Job Title: Strategic Housing Development at Colpe West, Drogheda,
Co. Meath

Report Title: Infrastructure Design Report

Report Reference: 170092-REP-010

SCALE 1:2000 @A1 FILE REF. 170092-3059
 DRG. NO. 170092-3059

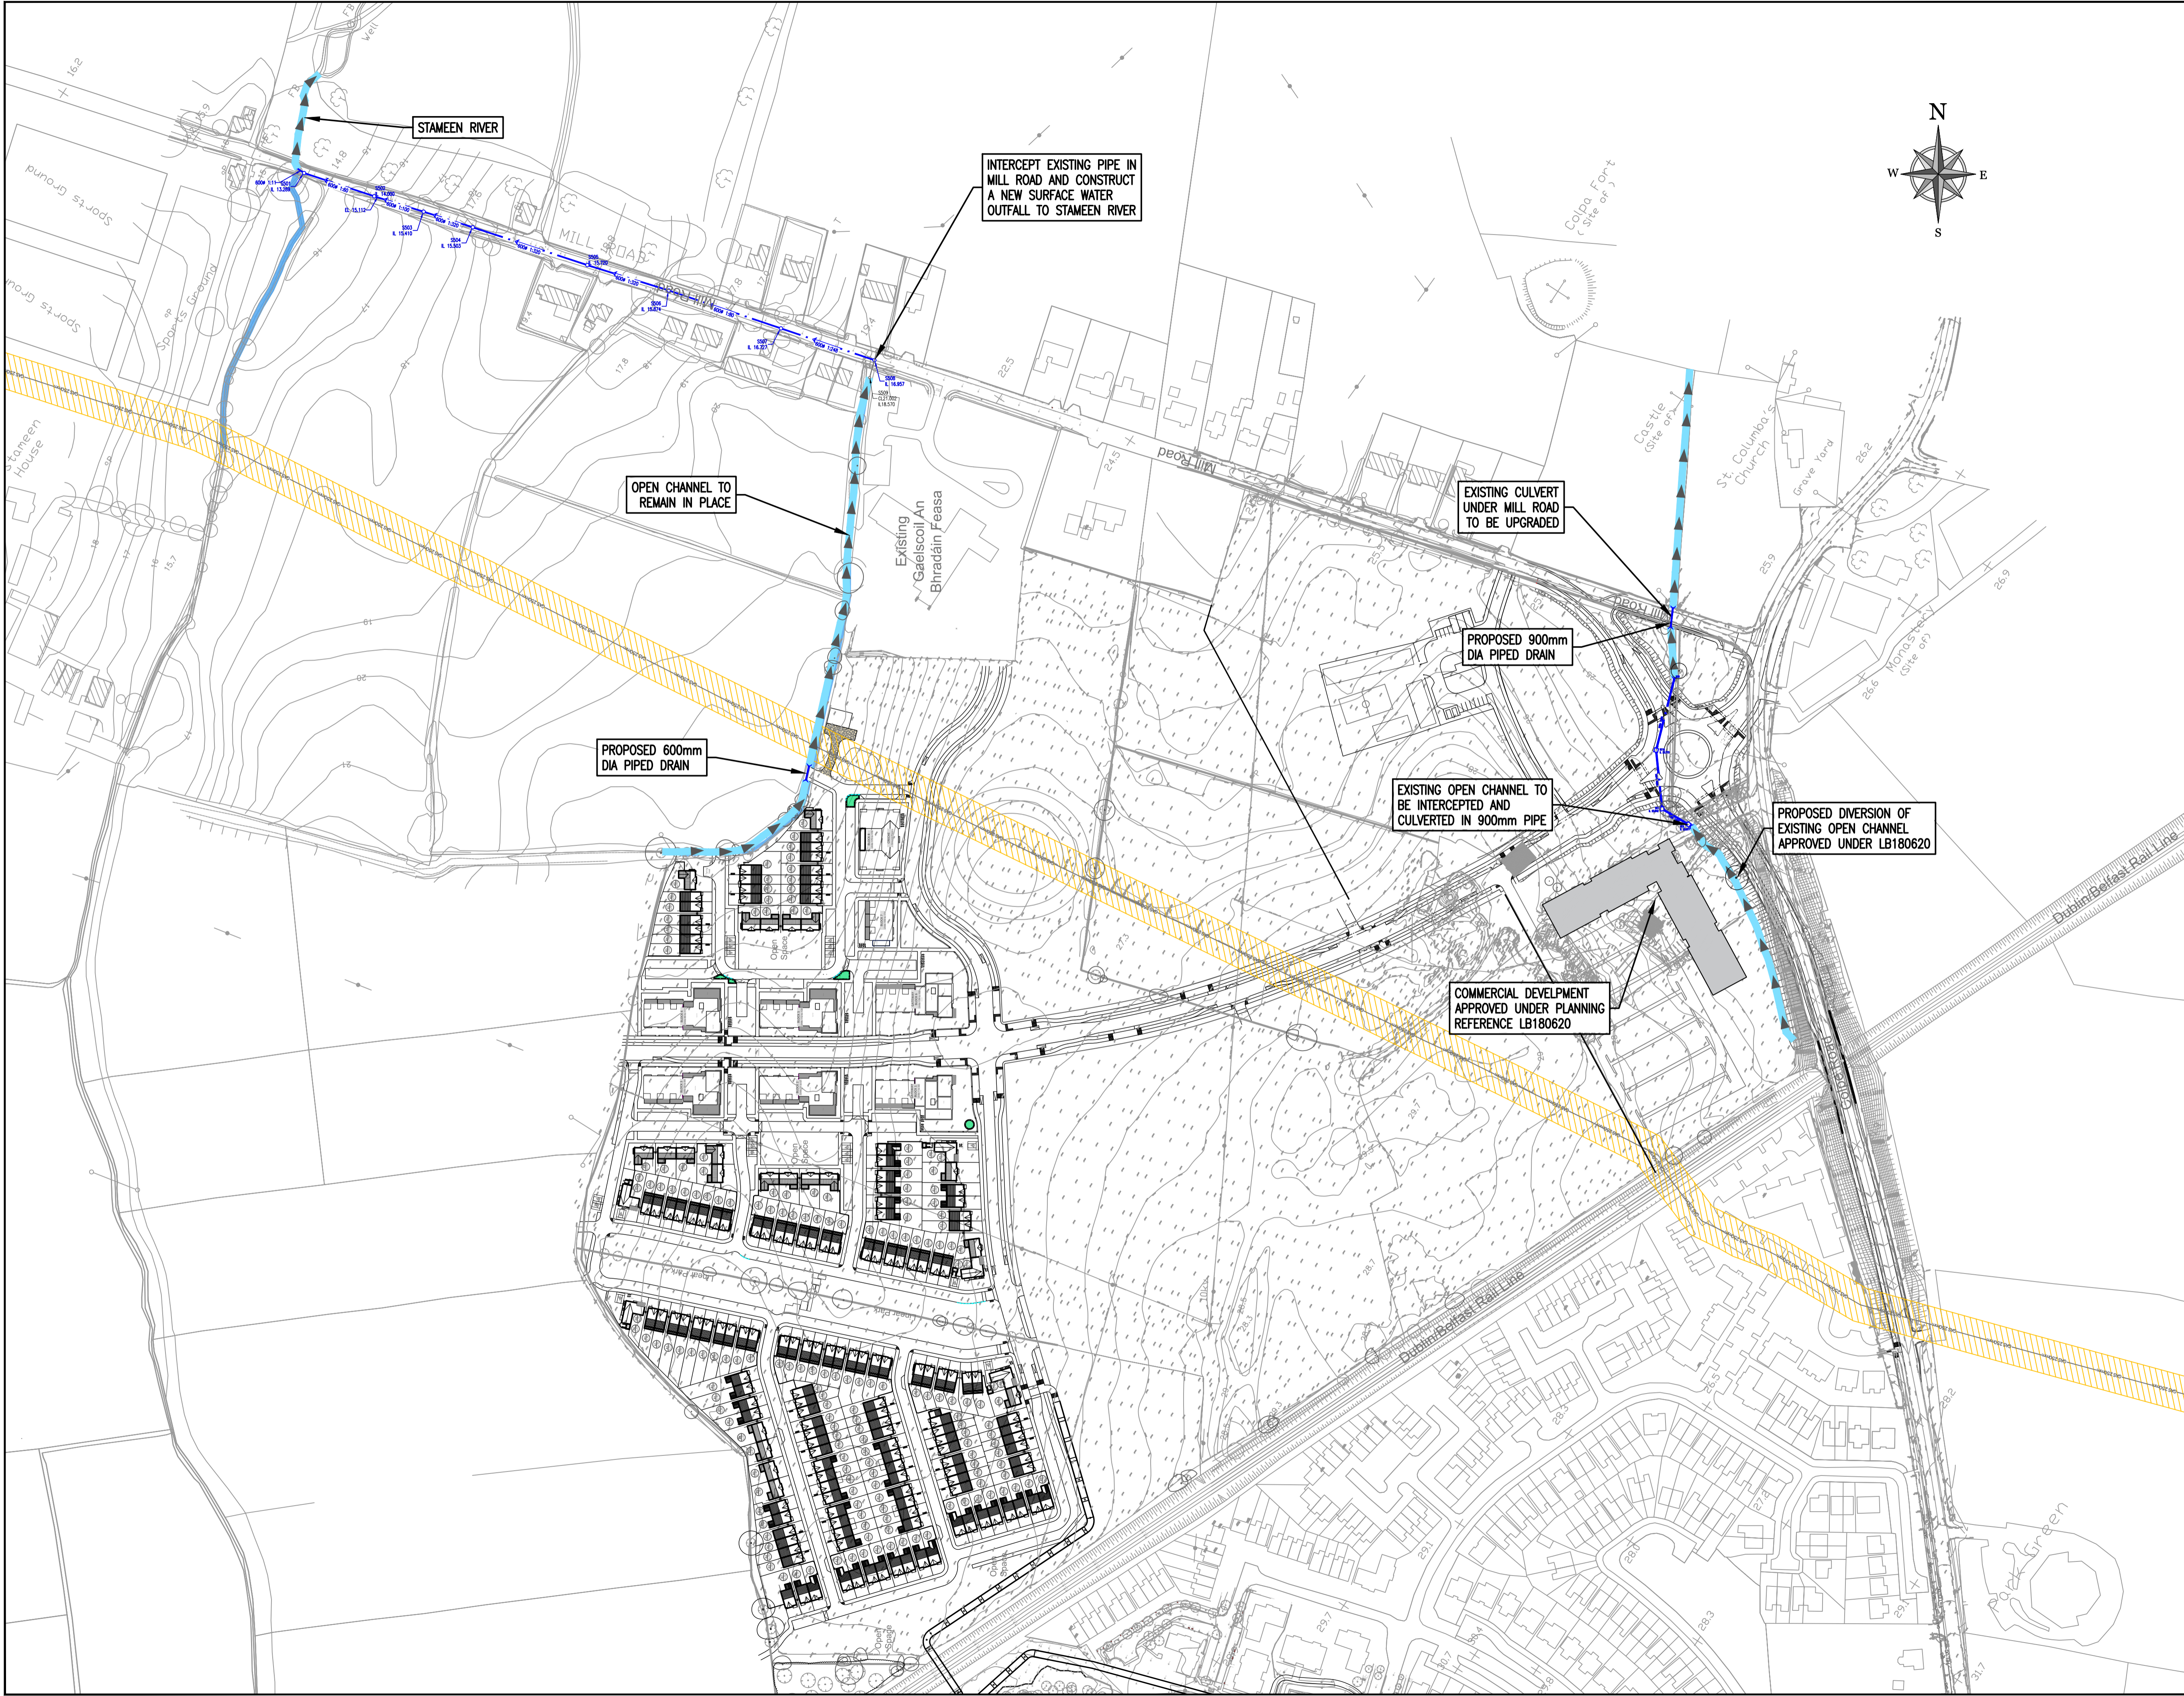
The development as proposed does not meet the requirements of Meath County Council Water Services Section with respect to the orderly collection, treatment and disposal of surface water. Meath County Council Water Services Section requires that the following matters be addressed prior to submission of an SHD application;

1. Meath County Council Water services consider the proposed attenuation volume to be undersized for the scale of development. The applicant shall provide justification for the use of the runoff factors applied to each of the "Surface Types" detailed in Table 2 of the "Infrastructure Design Report December 2018" which forms part of the applicants submission. The applicant shall also satisfy by means of additional

Refer to DBFL drawing no. 170092-3059.
